**Sent:** 15 September 2013 17:37  
**To:** Planning  
**Subject:** FW: Planning application s6/2013/1886/FP

**To:** [planning@welhat.gov.uk](mailto:planning@welhat.gov.uk)  
**Subject:** Planning application s6/2013/1886/FP  
**Date:** Sun, 15 Sep 2013 17:22:53 +0100

I would like to comment on this planning application.

ADDRESS : 5 ORCHARD CLOSE, EN6 4QD	
PROJECT TITLE : EXTENSIONS AND LOFT	
DRAWING TITLE : PROPOSED	
drawn MIDAS PLANNING	scale 1 / 100 @ A3
date JULY 2012	dwg no. 378/03

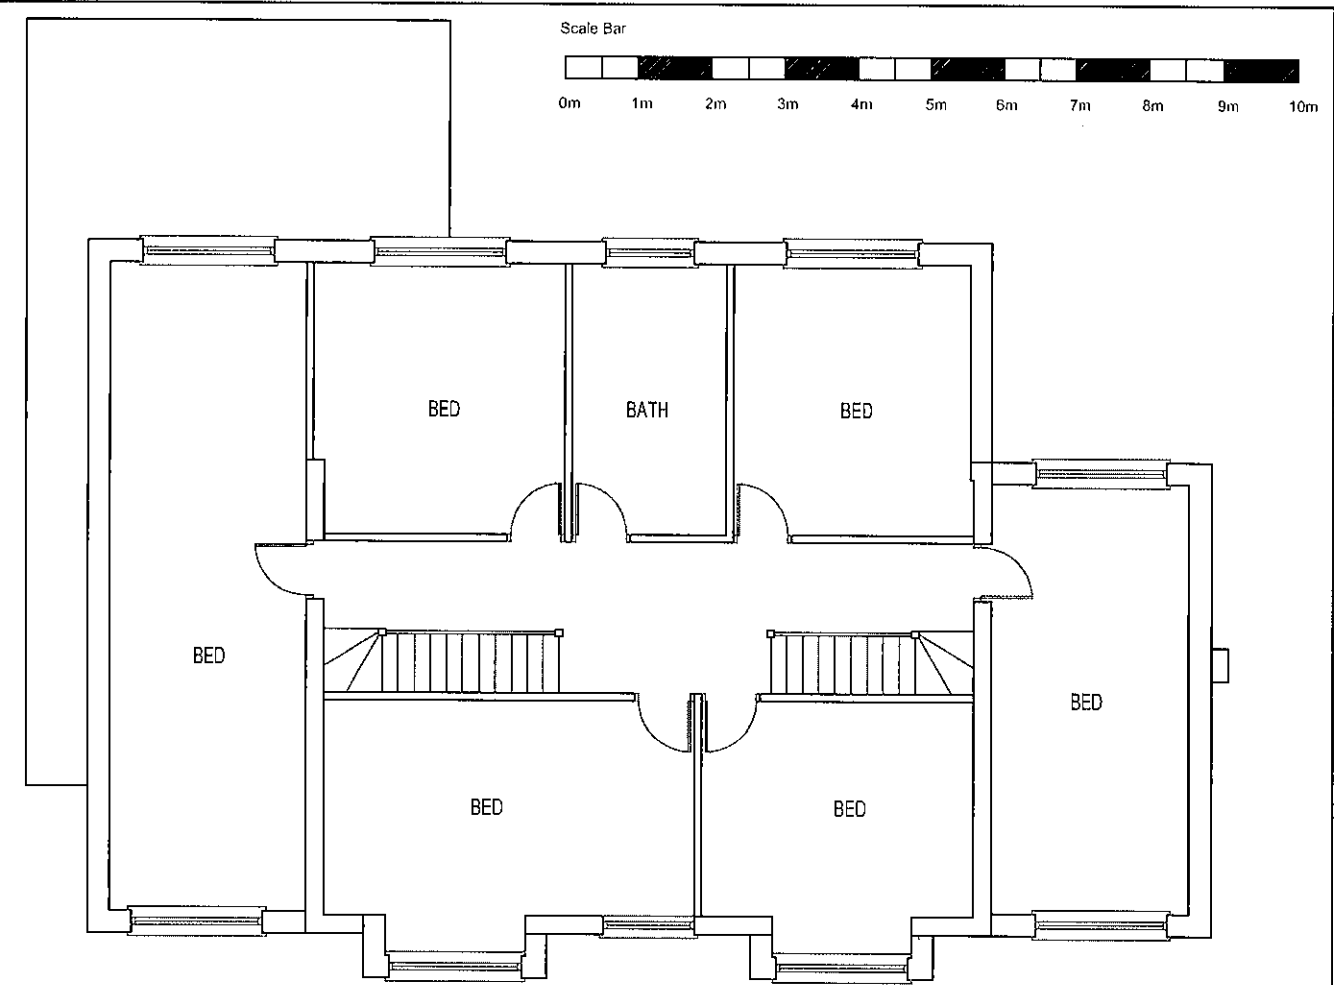
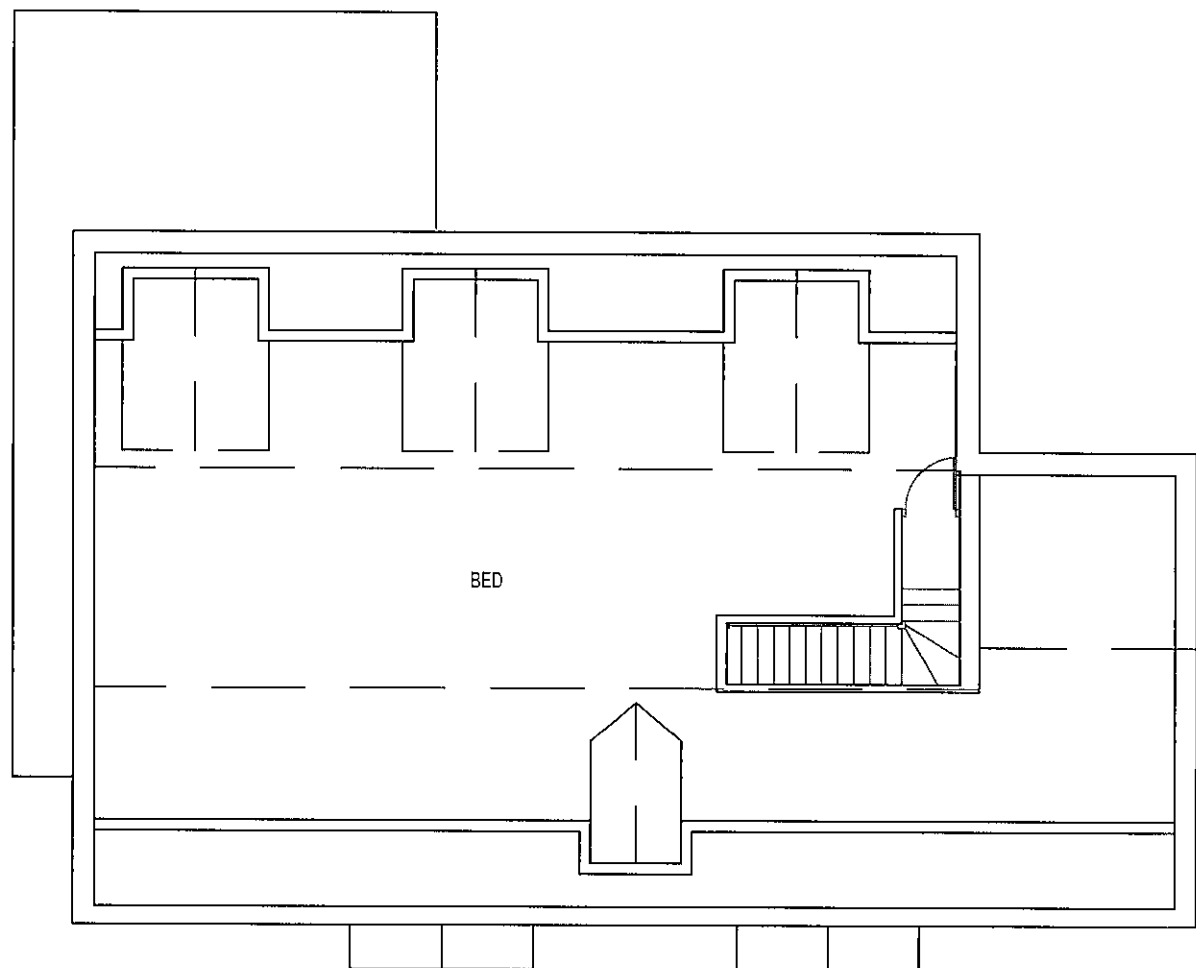
1. The plans show a substantial increase in size in the property which will be imposing on my family home.
2. The increase in size will result in the first and second floor windows having unobstructed views directly into my living/dinning area as well as the garden. This has a precedent as my conservatory flank windows had to be obscured for the same reason.
